Response to Submissions State Significant Development Application 7382

University of Technology Sydney

UTS Central Project

August 2016 ■ 15746

South (Broadway) Elevation
1:250 @ A1

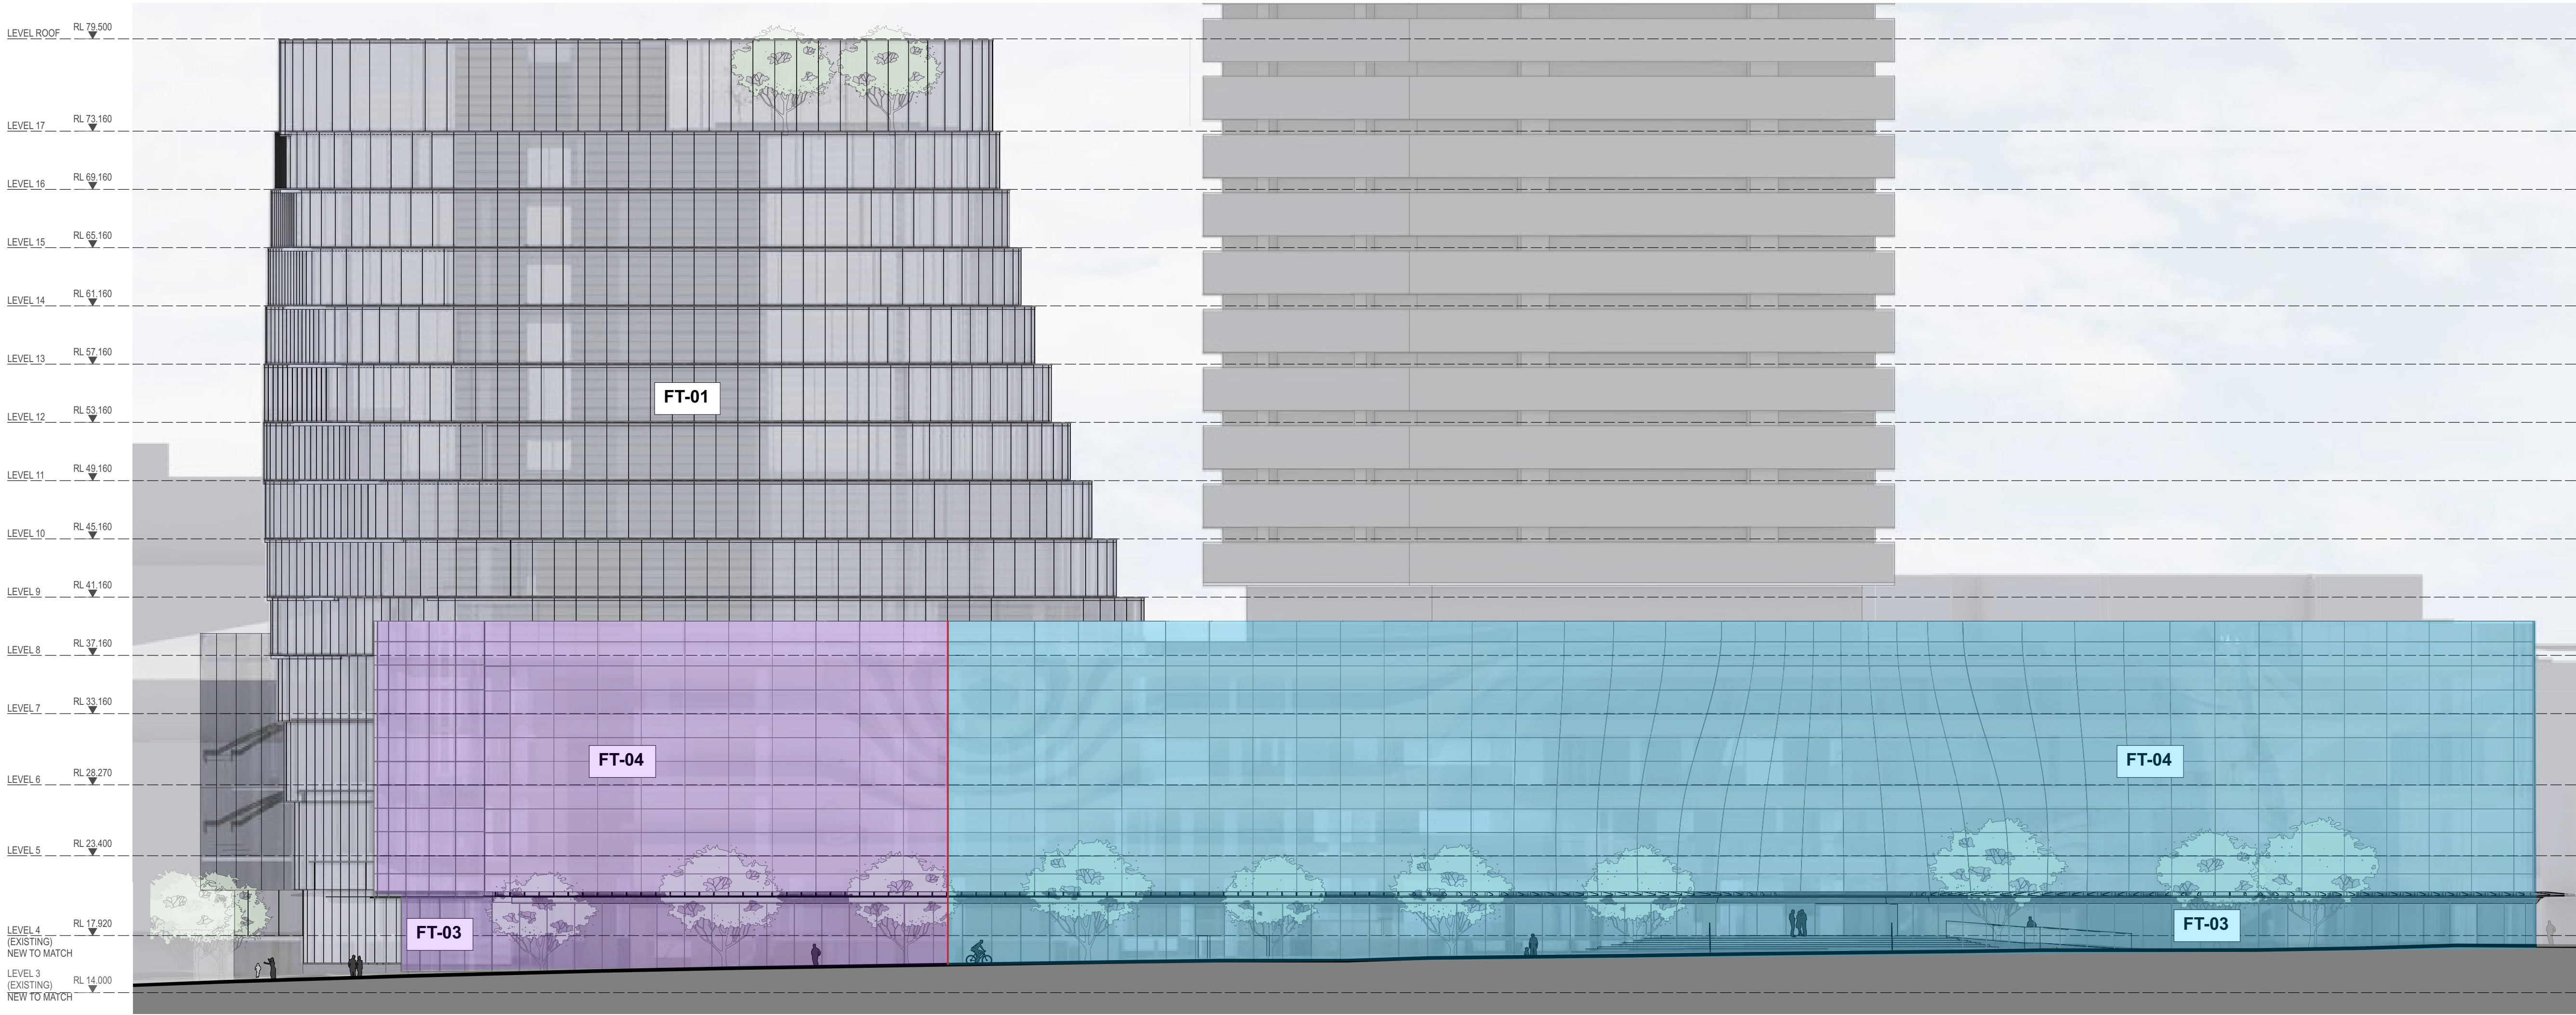
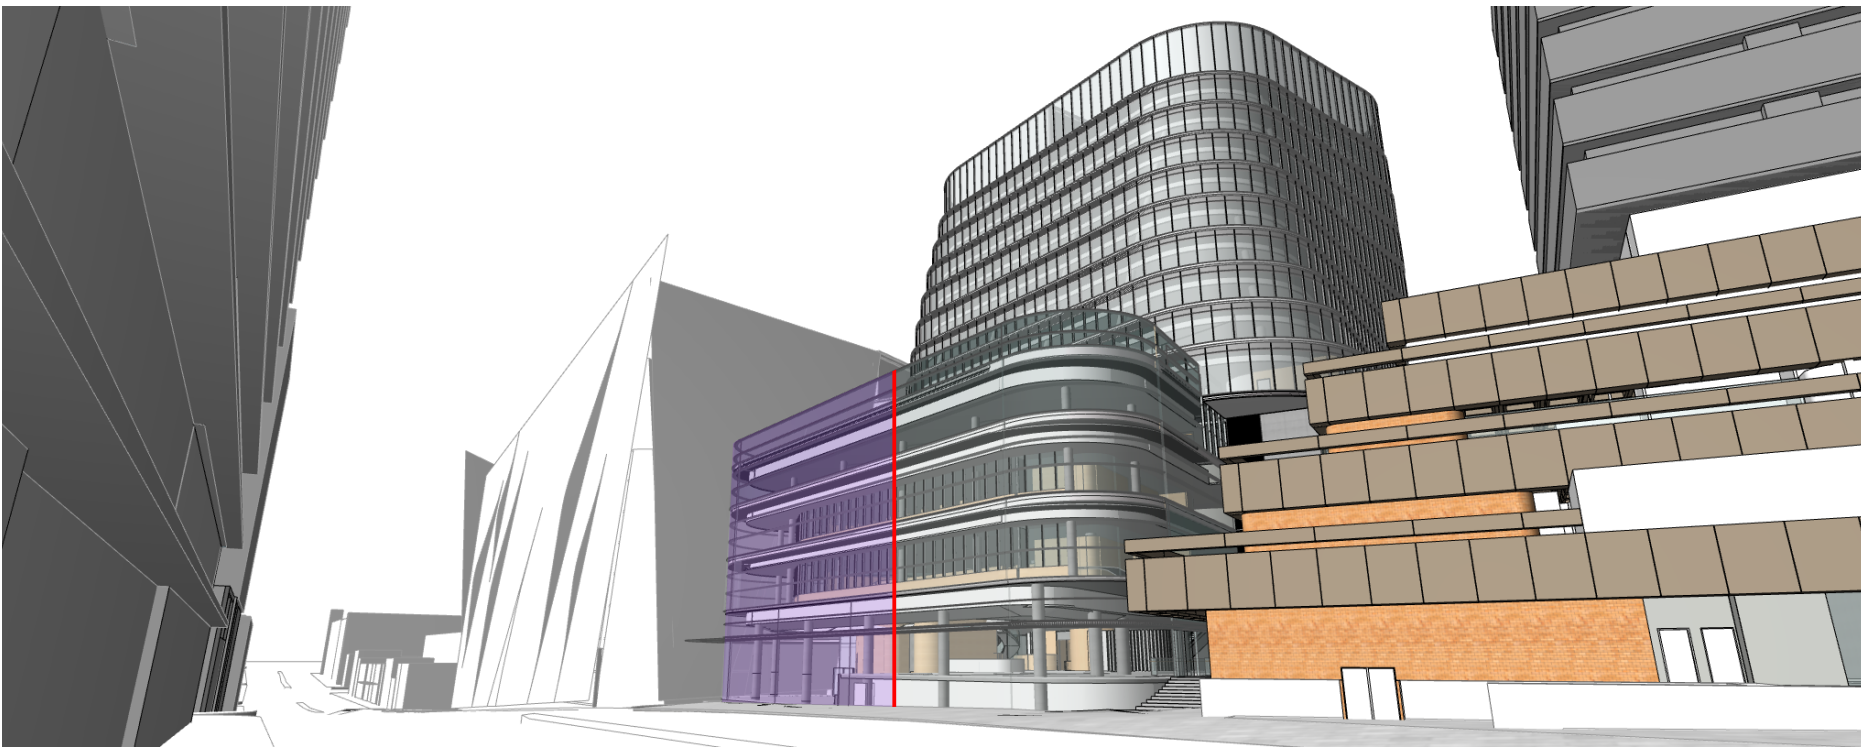
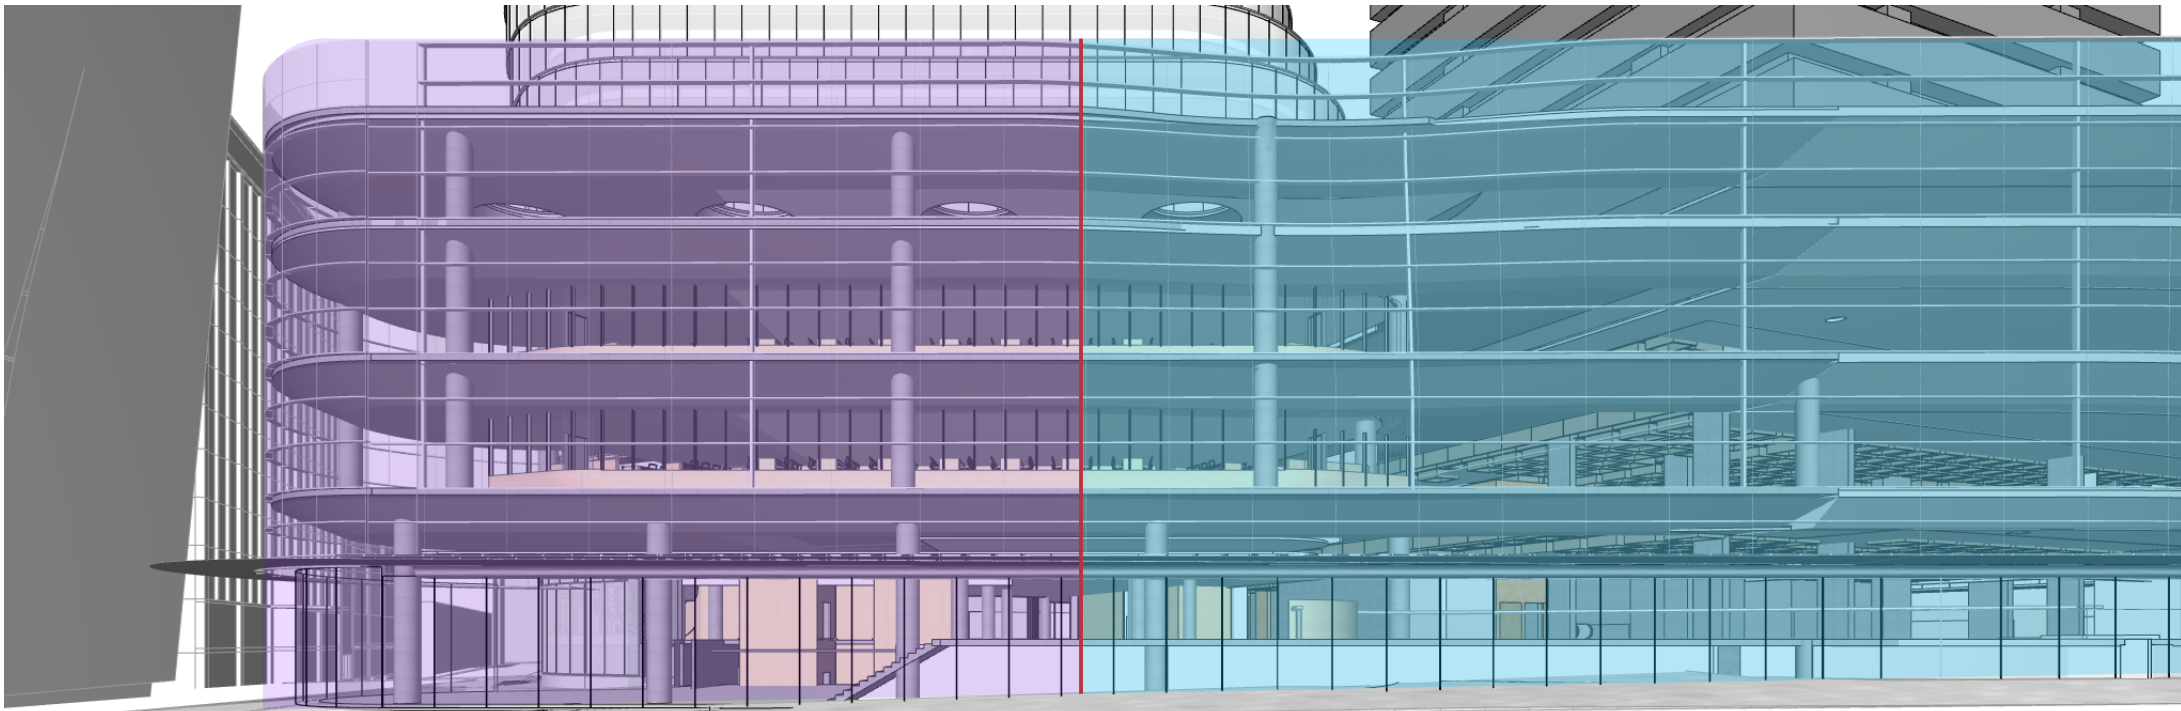
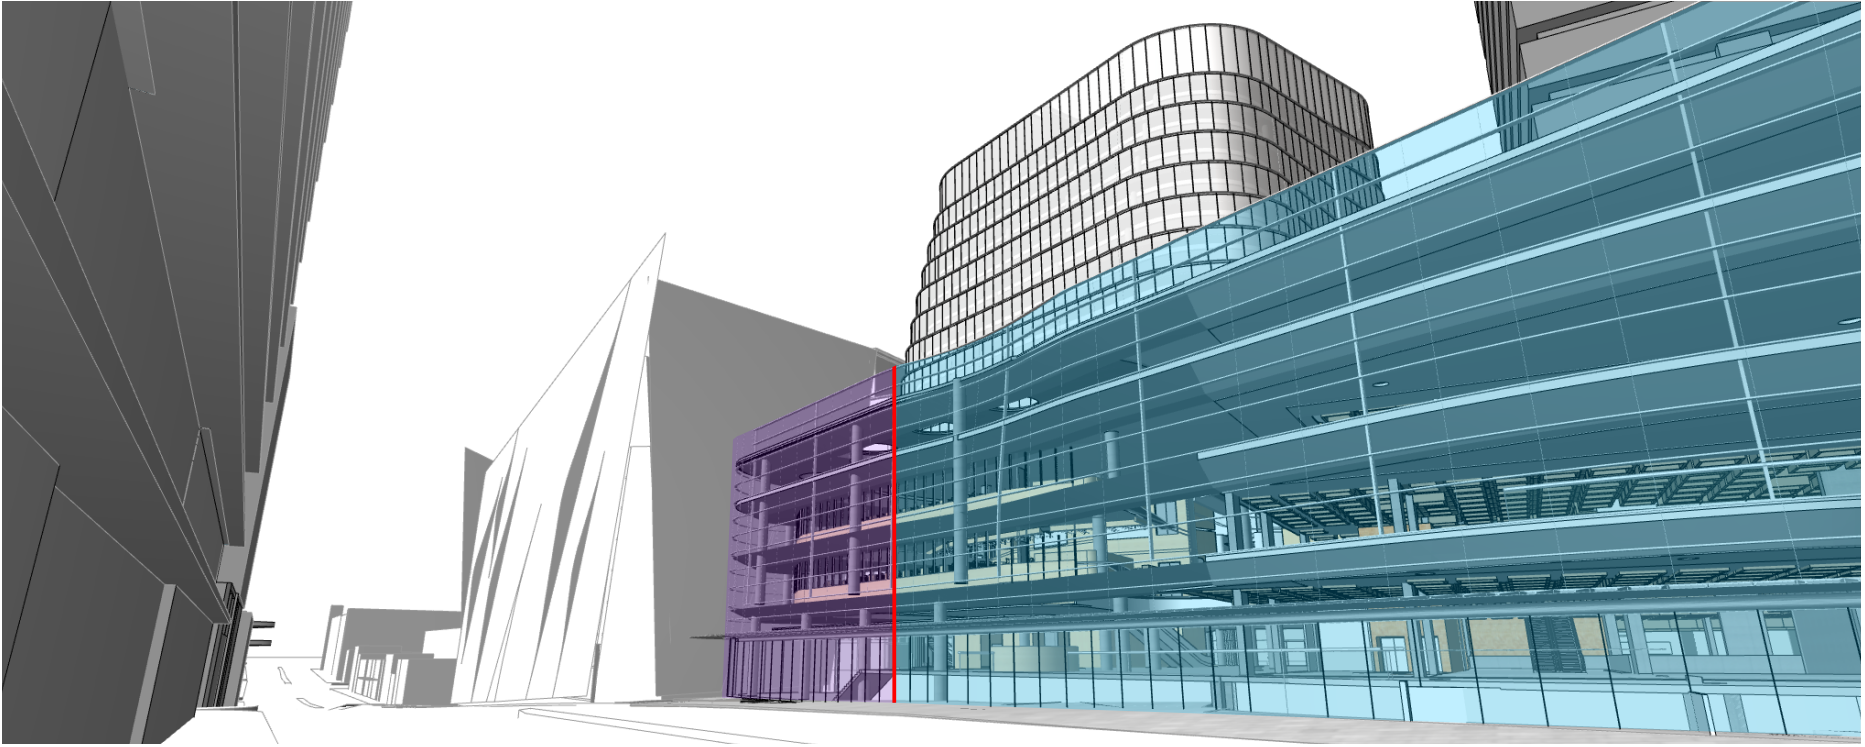
- *Review proposed staging to ensure delivery of a continuous integrated Broadway façade:*

The Department has requested that staging plans (including elevations and montages) be provided to:

- Illustrate how the Building 2 podium would appear upon completion of the Phase 1 Works;
- Demonstrate how the interim façade to Broadway would achieve design integrity with the final podium design; and
- Demonstrate how the interim design would be integrated with the final podium design.

The anticipated staging of the project is required to maintain key operations to UTS and the Broadway Campus. The opportunities to deliver an integrated Broadway facade has been carefully considered to develop a strategy of 'stitching' the facade along Broadway to deliver a seamless and continuous facade. This will be achieved by maintaining a consistent approach to the proposed facade types along Broadway allowing staging to occur with minimal to no representation of the differing timelines for the phased works.

Refer to images and drawings attached at **Appendix B** which reference staging of phase 1 and 2.

A set of staging plans (including elevations and montages) has been prepared by FJMT and is submitted with this report at **Appendix B**.
